KIRKLEES METROPOLITAN COUNCIL INVESTMENT & REGENERATION SERVICE

DELEGATED DECISION TO DETERMINE APPLICATIONS FOR CONSENT, AGREEMENT OR APPROVAL REQUIRED BY CONDITION

Reference No:	2024/44/92949/E
Site Address:	Land off Bankwood Way, Birstall Retail Park, Birstall, Batley, WF17 9DT
Description:	Discharge of conditions 9 (retaining walls), 17 (Phase II Report), 18 (remediation), 21 (coal mining), 23 (charging facilities), 24 (facing materials) and 27 (construction management plan) of previous permission 2021/92528 for erection of retail development, associated parking, servicing areas and landscaping
Recommending Officer:	William Simcock

Officer Report 2024/92949

Scale: AS SHOWN	Page Size: A1	Status: TENDER
Drawn by: SG	Date: APRIL 2023	Checked: MM
Project No: 24062-SDS-00-XX-DR-C-3050		Revision: T3

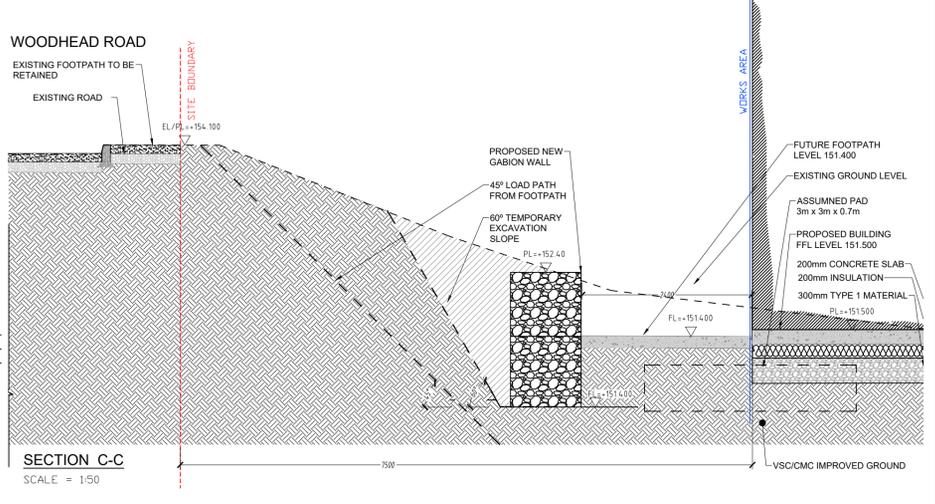
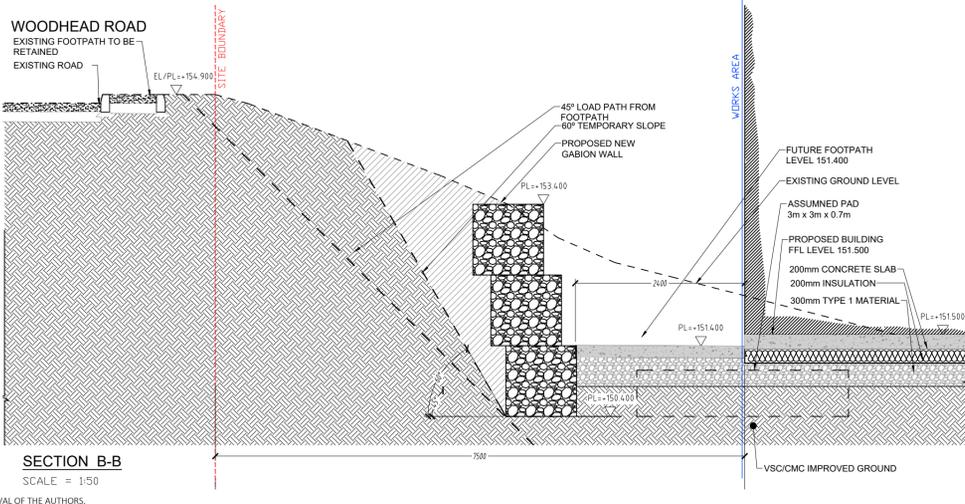
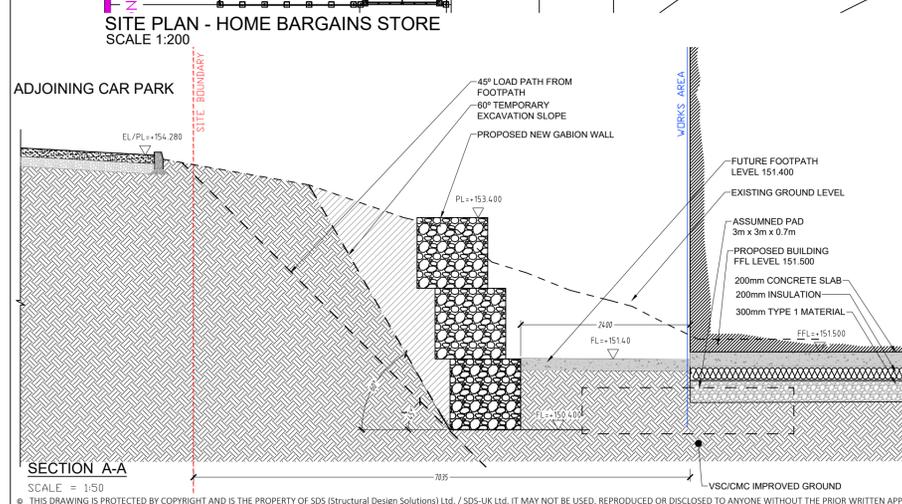
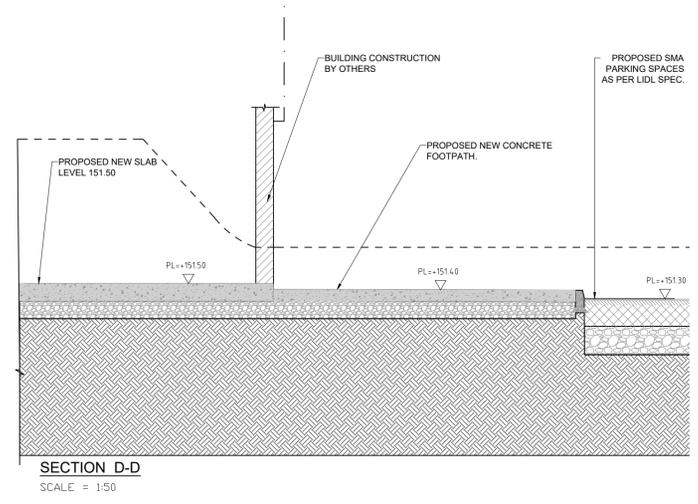
- Proposed gabion wall sections, 24062-SDS-00-XX-DR-C-3050 T3
- Proposed gabion wall elevations, 24062-SDS-00-XX-DR-C-3051 T3
- Sections through proposed RC (reinforced concrete) walls, 24062-SDS-00-XX-DR-C-3052 T3, 3053 T3, 3054 T2, 3055 T3

The plans already submitted and approved for AIP purposes must therefore be treated as superseded. The more recent plans are at an early stage in the process of assessment for AIP and cannot be approved for planning purposes until a new AIP has been granted. This condition therefore cannot be discharged at this stage.
